**WELWYN HATFIELD BOROUGH COUNCIL
EXECUTIVE DIRECTOR - PLANNING, PUBLIC PROTECTION AND GOVERNANCE**

Application No: 6/2018/1293/LAWP
Location: 21 Holme Road Hatfield AL10 9LH
Proposal: Certificate of lawfulness for a hip to gable roof alteration and construction of a rear dormer window
Officer: Ms Emily Stainer

Recommendation: Granted

Drawing Title :  
PROPOSED  
Elevation AA (Front), Elevation BB (Side)  
Section CC and Elevation DD (Rear)

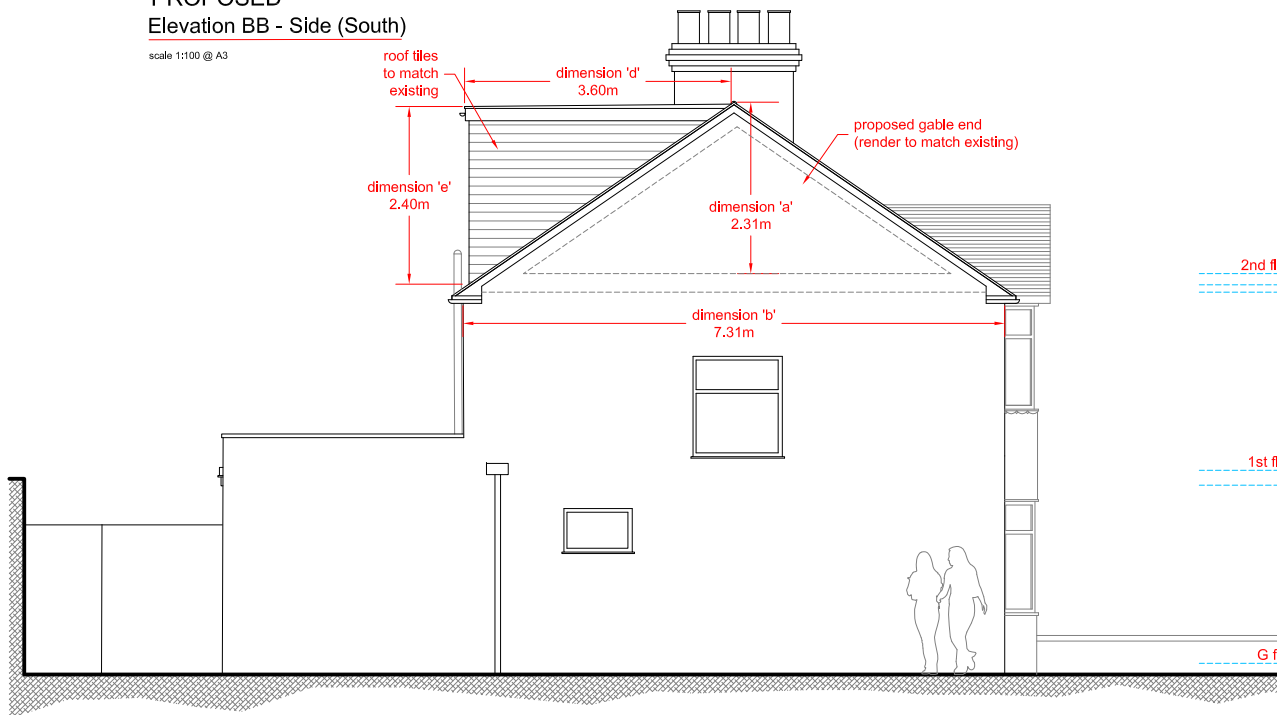
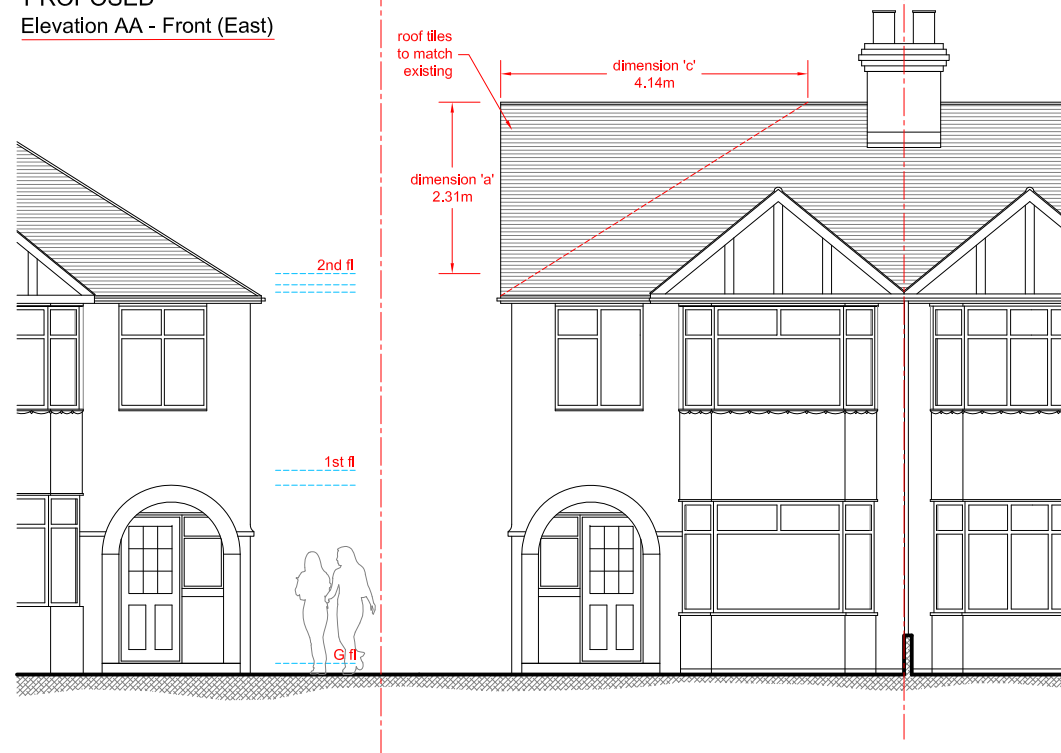
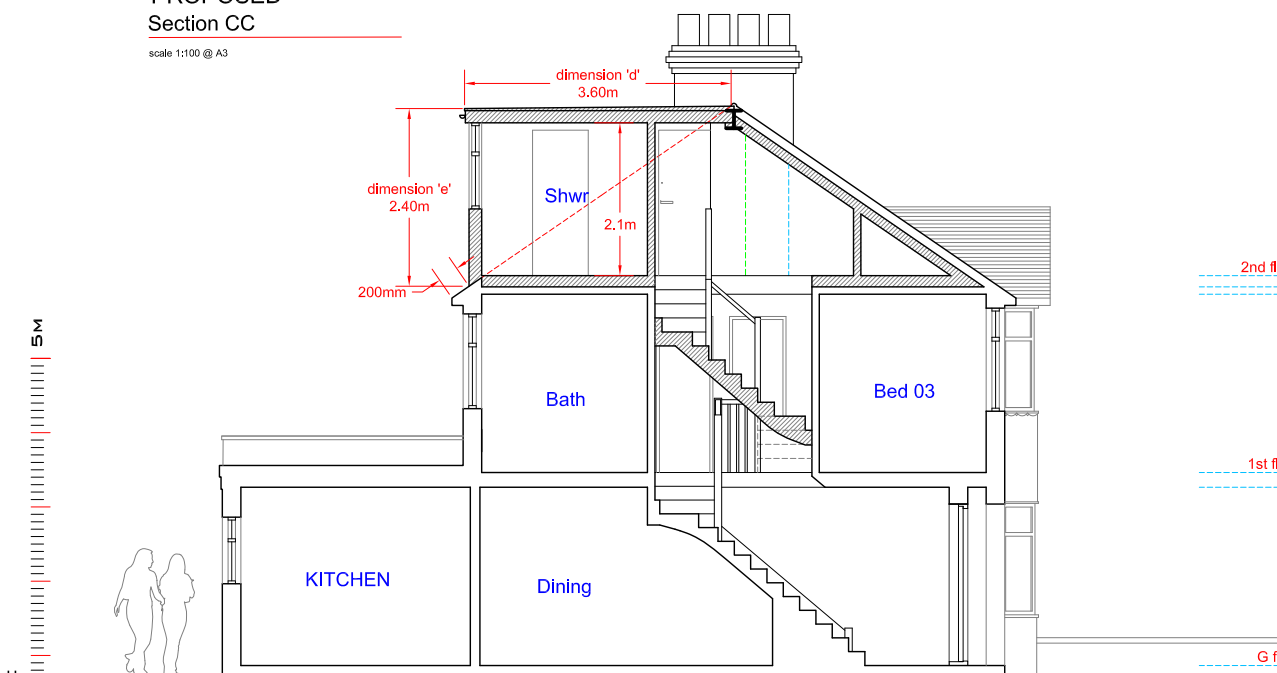
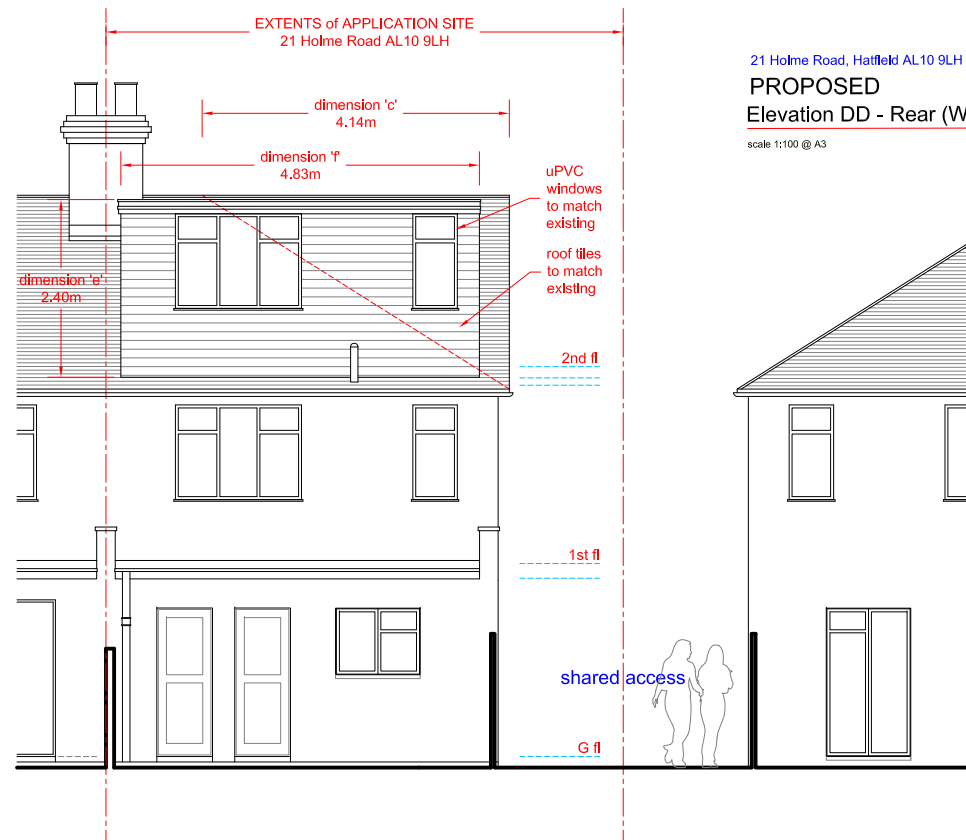
(b) would any part of the dwellinghouse, as a result of the works, exceed the height of the highest part of the existing roof	N	N
(c) would any part of the dwellinghouse, as a result of the works, extend beyond the plane of any existing roof slope which forms the principal elevation of the dwellinghouse and fronts a highway	N	N

(d) would the cubic content of the resulting roof space exceed the cubic content of the original roof space by more than:- (i) 40 cubic metres in the case of a terrace house, or (ii) 50 cubic metres in any other case	N	N
<i>Calculation:</i>		
<i>Volume of hip to gable: 2.31m x 4.14m x 7.31m /6 = 11.65m³</i>		
<i>Volume of rear dormer window: 2.4m x 3.6m x 4.83m /2 = 20.87m³</i>

Total = 32.52 m3		
(e) would it consist of or include:- (i) the construction or provision of a veranda, balcony or raised platform, or (ii) the installation, alteration or replacement of a chimney, flue or soil and vent pipe	N	N
